**WELWYN HATFIELD BOROUGH COUNCIL  
EXECUTIVE DIRECTOR - PLANNING, PUBLIC PROTECTION AND GOVERNANCE**

**DELEGATED APPLICATION**

**Application No:** 6/2021/0631/PN27  
**Location:** 35 Northaw Road East Cuffley Potters Bar EN6 4LU  
**Proposal:** Prior approval for the construction of an additional storey to facilitate the enlargement of the dwellinghouse to a maximum of approximately 9.607m in height  
**Officer:** Ms Emily Stainer

**Recommendation:** Prior Approval Required and Granted

PROPOSED SIDE ELEVATION

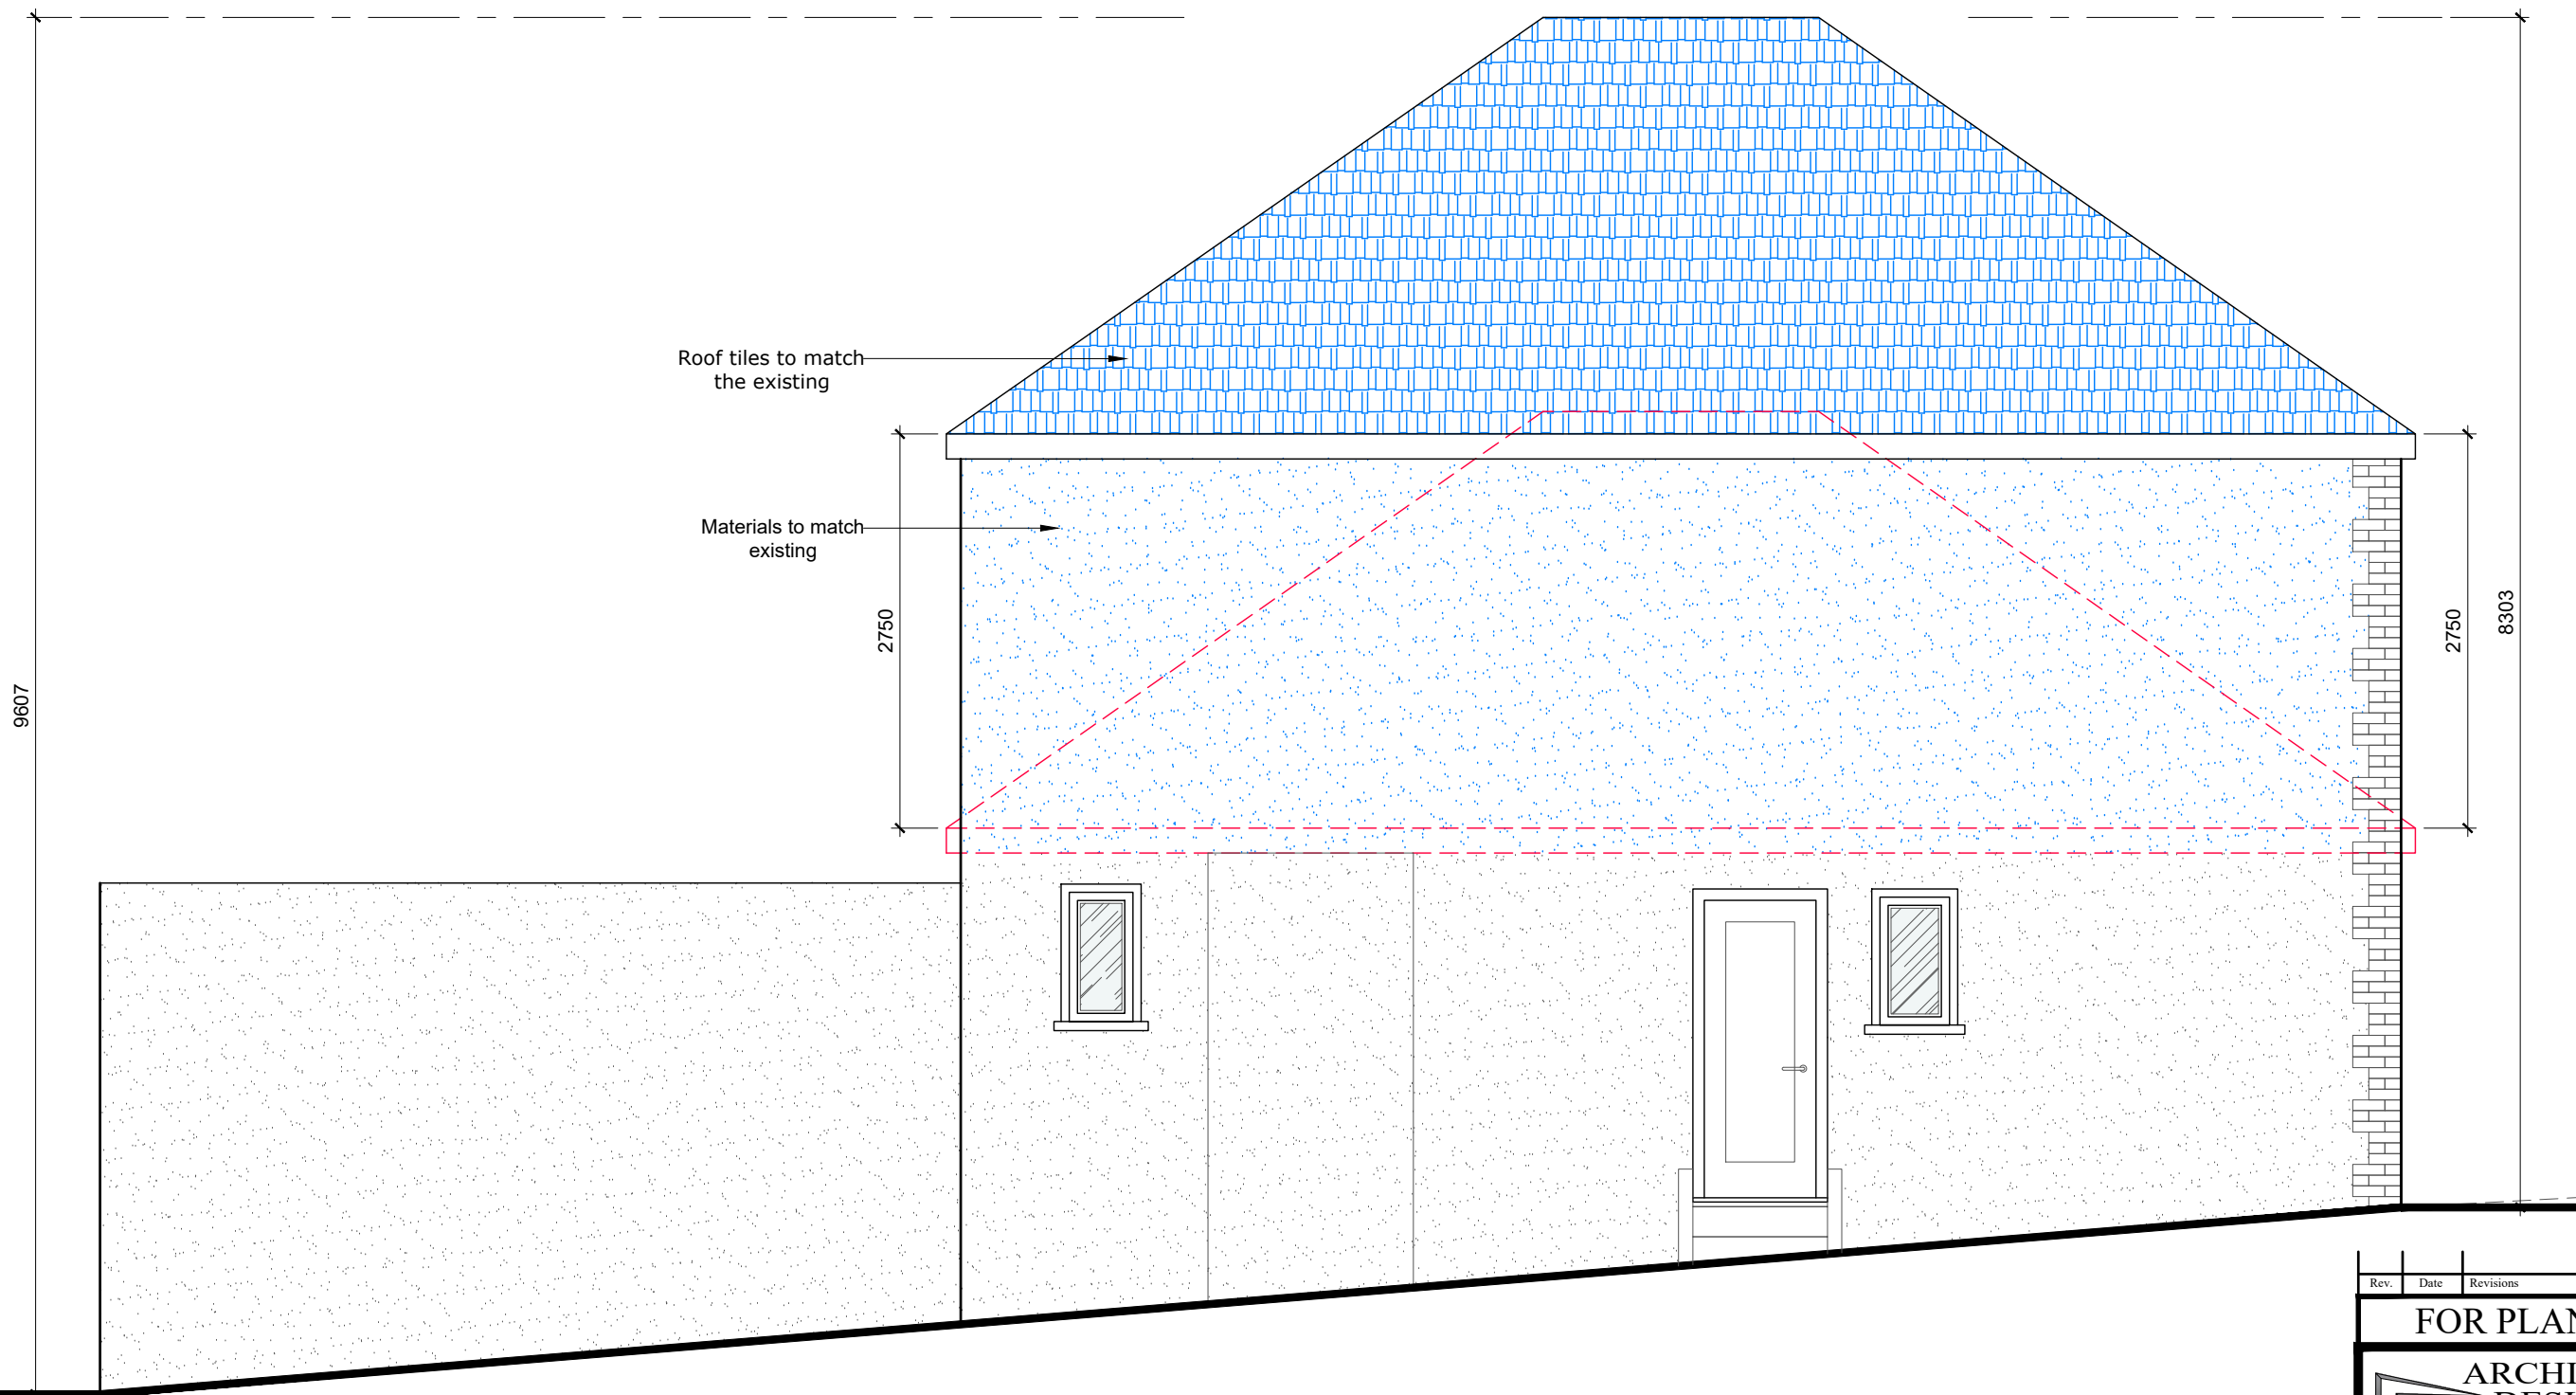
addition, the new storey and roof would be constructed using matching materials to the existing dwelling. On this basis it is considered the design and architectural features of the resultant dwelling would respect the principal elevation and design of the existing dwelling.
Air traffic and defence impacts	The dwelling would have minimal impact on air traffic and defence assets.
Whether because of the siting of the building, the development will impact on a protected view	The development would not impact on a protect view identified in the Directions Relating to Protected Vistas.
<b>RECOMMENDATION</b>	
<b>Prior approval required and granted</b>	
The proposal has been assessed against Schedule 2, Part 1, Class AA of the Town and Country Planning (General Permitted Development) (England) Order 2015 as amended and <b>prior approval is required and granted</b> . This is subject to a condition requiring the development to be carried out in accordance with the construction management plan that was submitted on 24 <sup>th</sup> February 2021 which sets out the proposed development hours of operation and how any adverse impact of noise, dust, vibration and traffic on adjoining owners or occupiers will be mitigated.
